Section 75W Modification Application (MP07_0070) - Wollongong Private Hospital, 360-364 Crown Street Wollongong

Further to your correspondence dated 27 August 2013 regarding submissions received during the exhibition period in relation to the subject 75W Modification Application, please find below our response to the matters raised.

Drawn KC	Checked HS	Date 17.05.13	Scale 1:500 © A3
Drawing Title URUNGA PARADE AND WEST ELEVATIONS

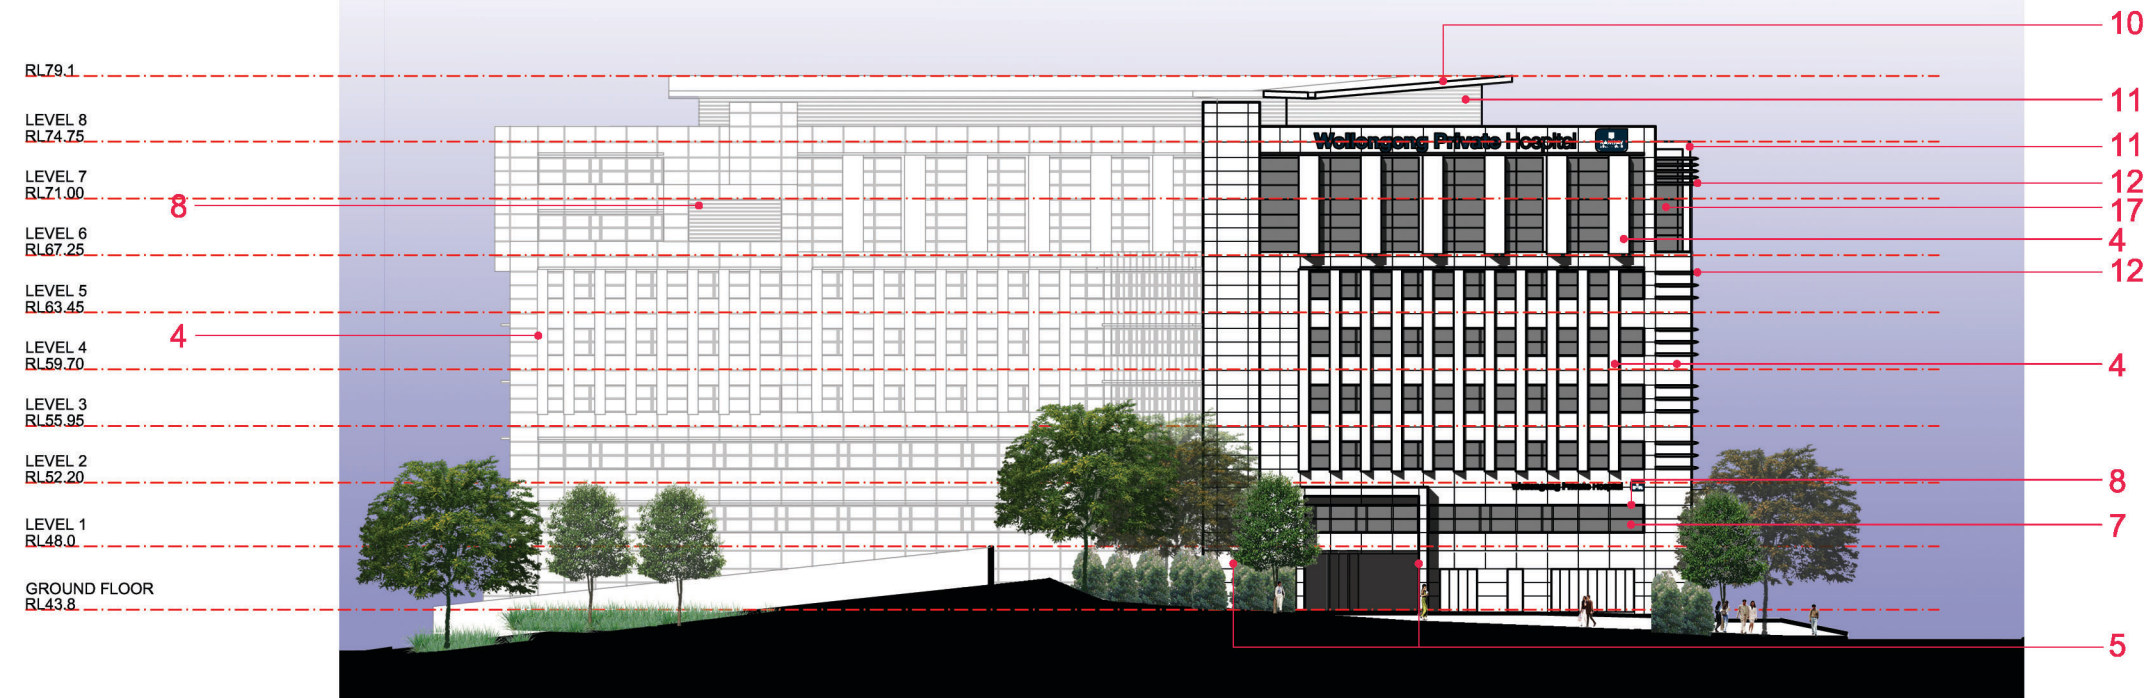
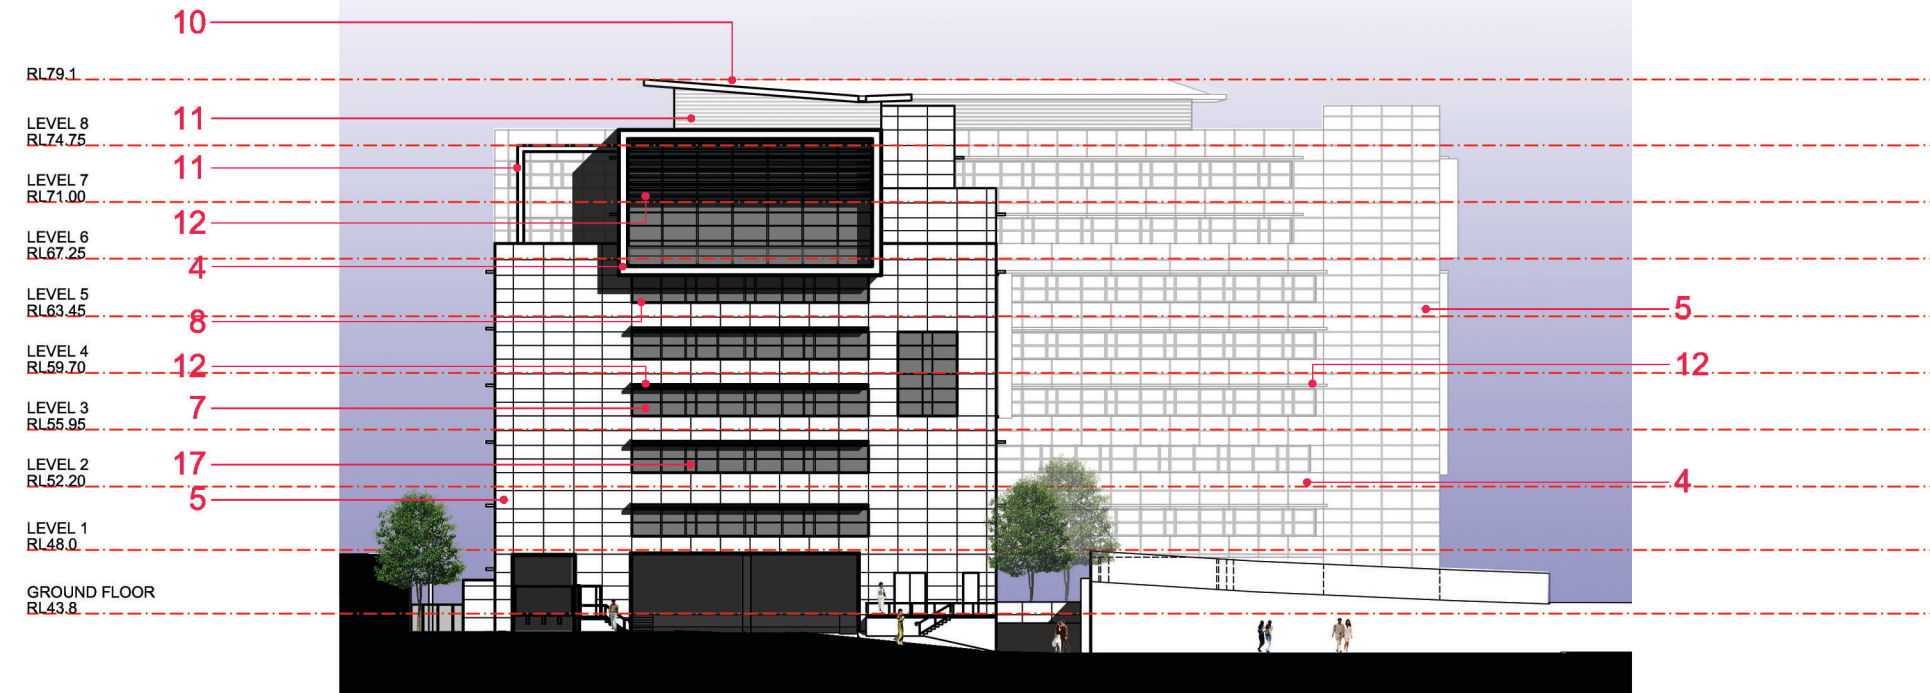
The comments provided by NSW Roads and Maritime Service are noted with respect to this modification application. Accordingly, the vehicle access from Urunga Parade has been re-instated to alleviate traffic volumes on the Crown Street entry and provide more appropriate network accessibility. Prior to this vehicle access being finalised, discussions were held with the RMS to ensure all matters were addressed, thus confirming the design is acceptable.

The provision of vehicle access from Urunga Parade has required the civil/stormwater plans be amended to accommodate the change in levels throughout the site, in particular adjacent the re-instated vehicle access point.
